Application No: BR/37/21/TEL
Site Address: Junction of Lyon Street West and Richmond Road Bognor Regis PO21 1LF
Description of works: Prior Notification under Schedule 2, Part 16 for a proposed 20.0m Phase 8 Monopole C/W wrapround Cabinet at base and associated ancillary works.

Thank you for your internet representation made on 24th March 2021 which has been recorded as an objection with the comments as follows:

Title:
210 PROPOSED H3G SITE PLAN

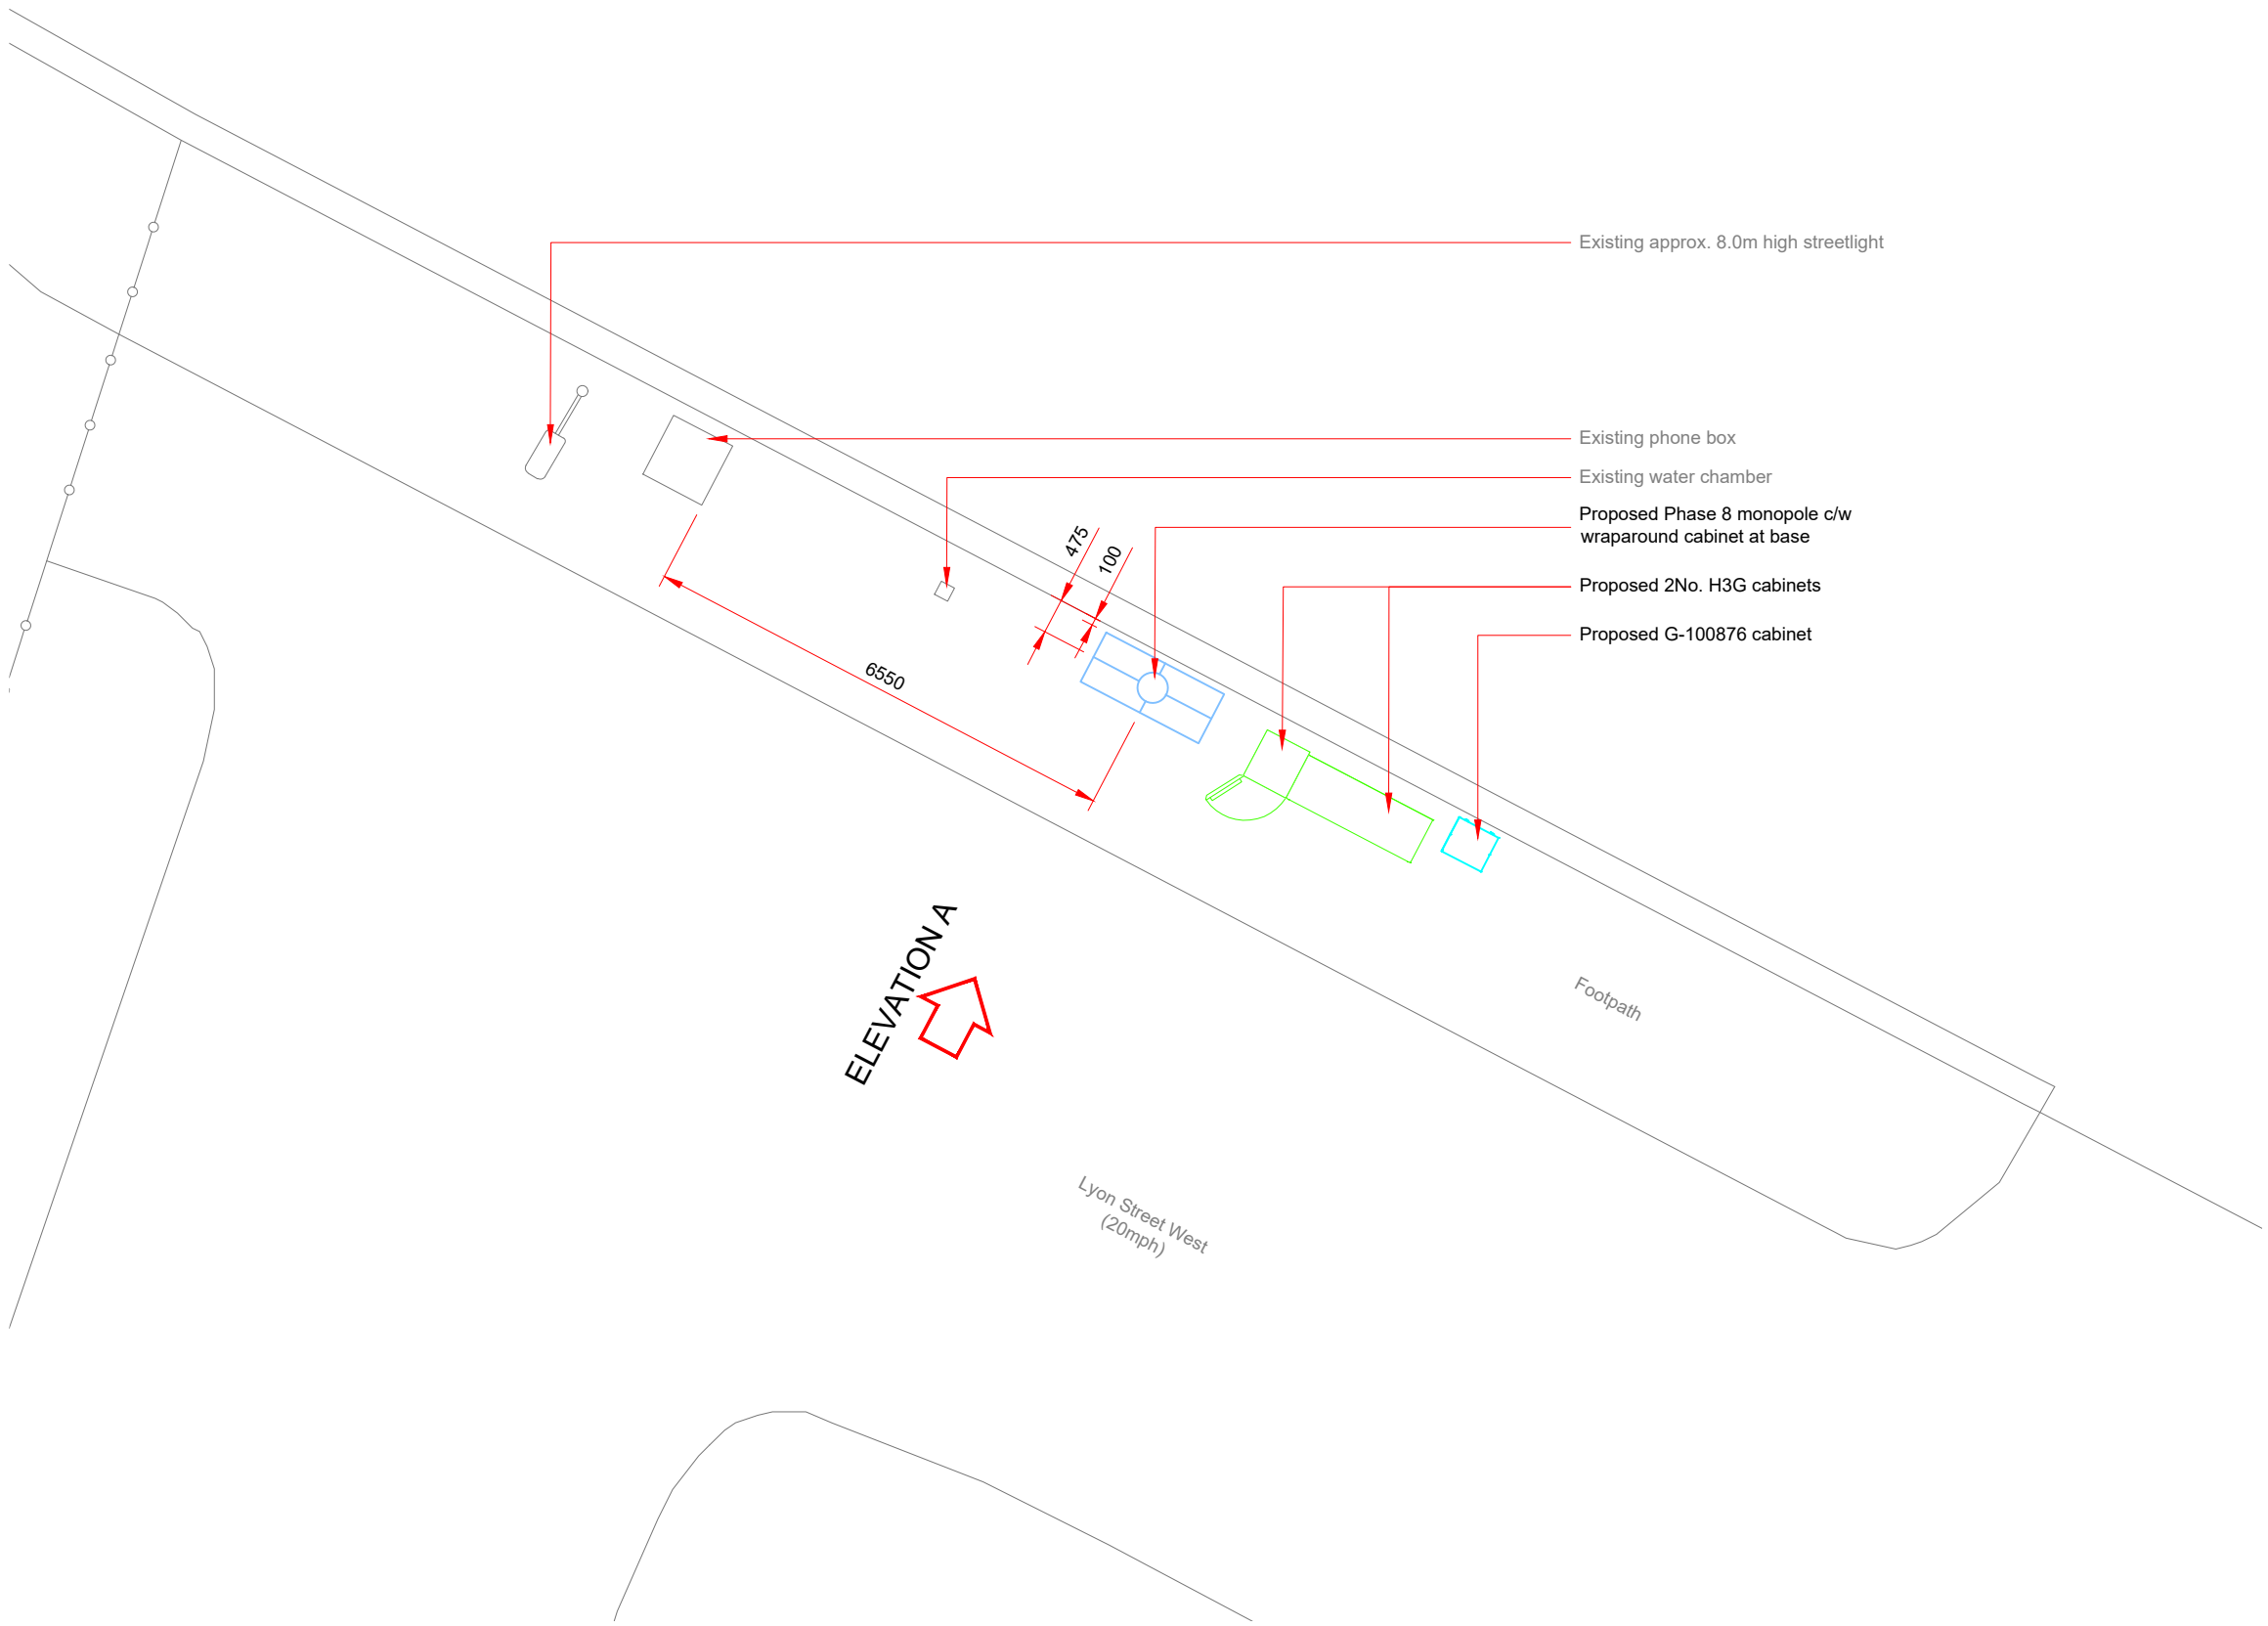
The need for a 5G mast in this location is to be questioned, due to the close proximity of 5G antennae on Fitzleet House, a few streets away. Where is the technical data to show that the combined power output of these two groups of apparatus will not exceed the guidelines? No exclusion zone is shown on the diagram and there is a block of flats in close proximity to the proposed location of the mast. I have seen exclusion zones marked on planning applications for masts, made to other Councils eg. Bath and North East Somerset 20/04924/FUL, so I don't see why the same should not apply for Arun. In summary, I believe that these two omissions count as a material defect in the application and that it should be rejected.
